APPLICATION FOR ZONING AMENDMENT
City of Portland, Maine
Department of Planning and Urban Development
Portland Planning Board

RE: Site Plan Review
Marriott Courtyard
2282 Congress Street

I have reviewed the Applicant's latest submission dated 9/14/99 for items outlined in a September 2, 1999 memorandum by Jim Wendel. I offer the following comments:

PROJECT
MULTI-USE DEVELOPMENT
 2282 CONGRESS ST., PORTLAND, ME
 SHEET TITLE
UTILITY PLAN
 CLIENT
 CJ DEVELOPERS, INC.
 35 PRIMROSE LANE, FREEPORT, MAINE 04032
 AND PORTLAND PROPERTY HOLDINGS, LLC
 2 MAIN STREET, SUITE 200, TOPSHAM, MAINE 04086

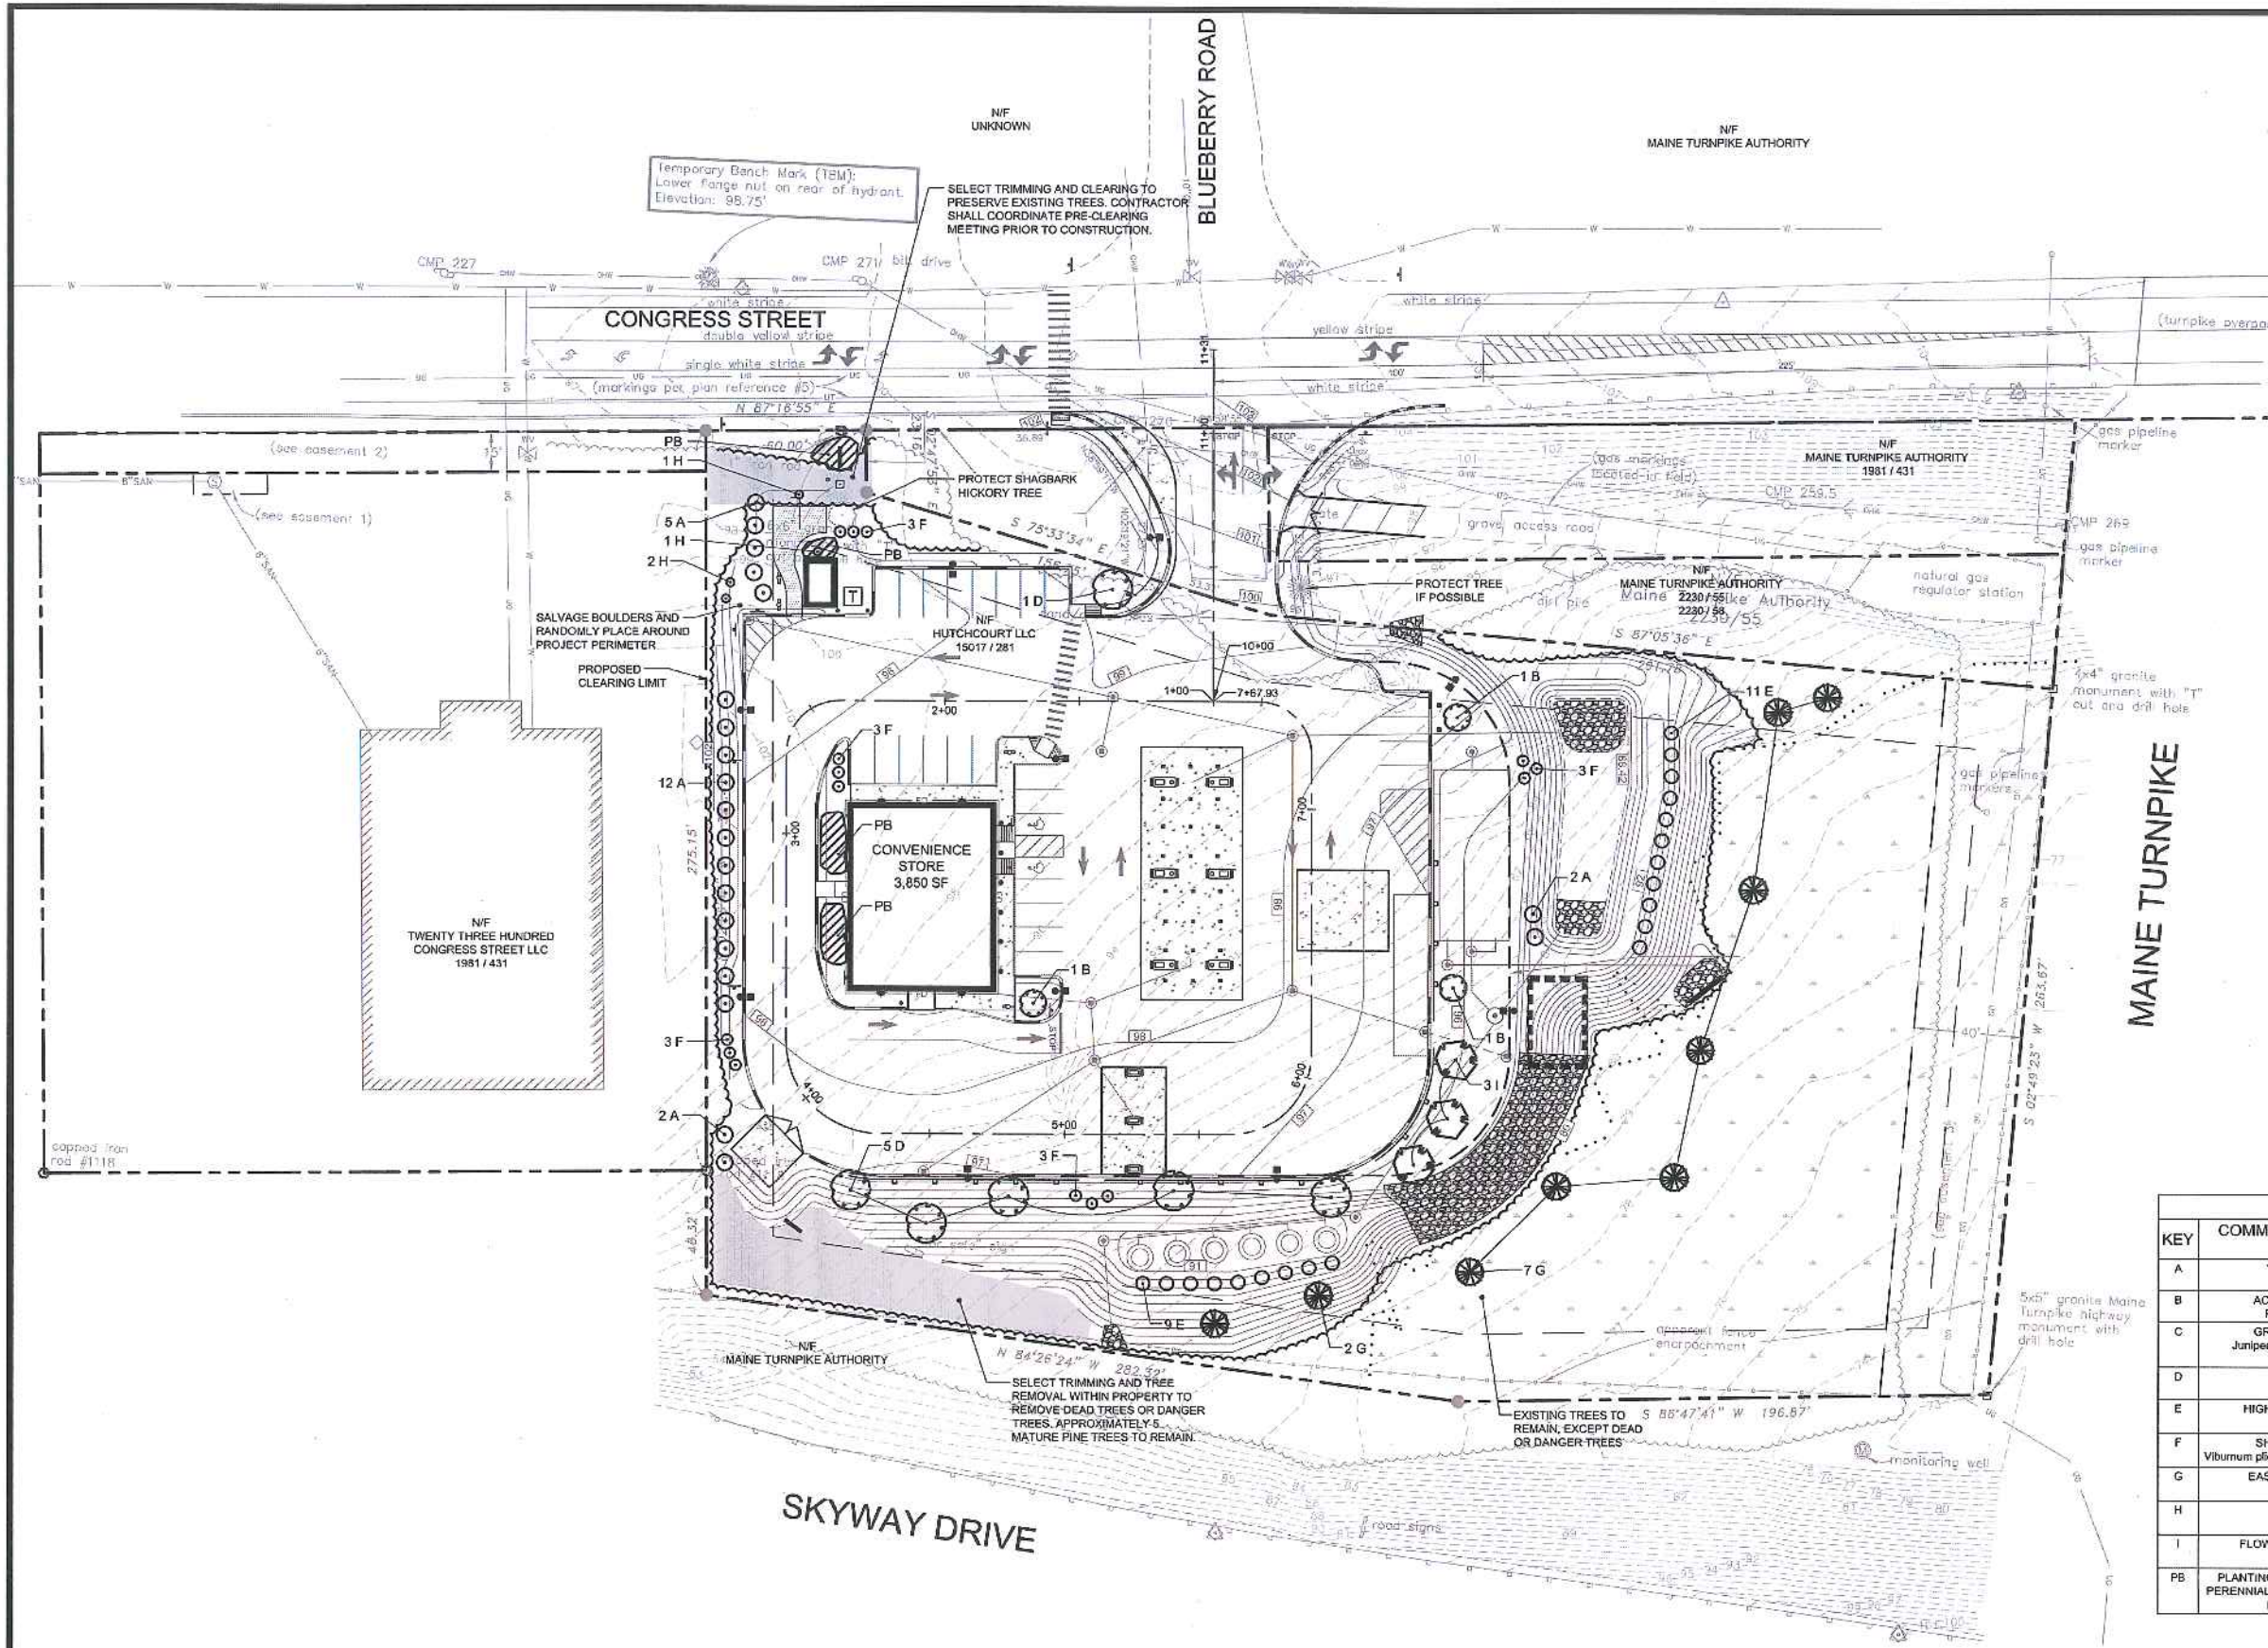
1. The Applicant has addressed items 1-16 outlined in Mr. Wendel's memorandum and the plans appear to meet the City Standards for stormwater management and erosion control.
2. The Applicant should review the proposed sanitary sewer service for minimum slope. The typical minimum slope for 8" pipe is 0.004 ft./ft. and for 10" pipe it is 0.0028 ft./ft. The Applicant should either try to steepen their slope from 0.0030 to 0.0040 or install 10" diameter pipe.
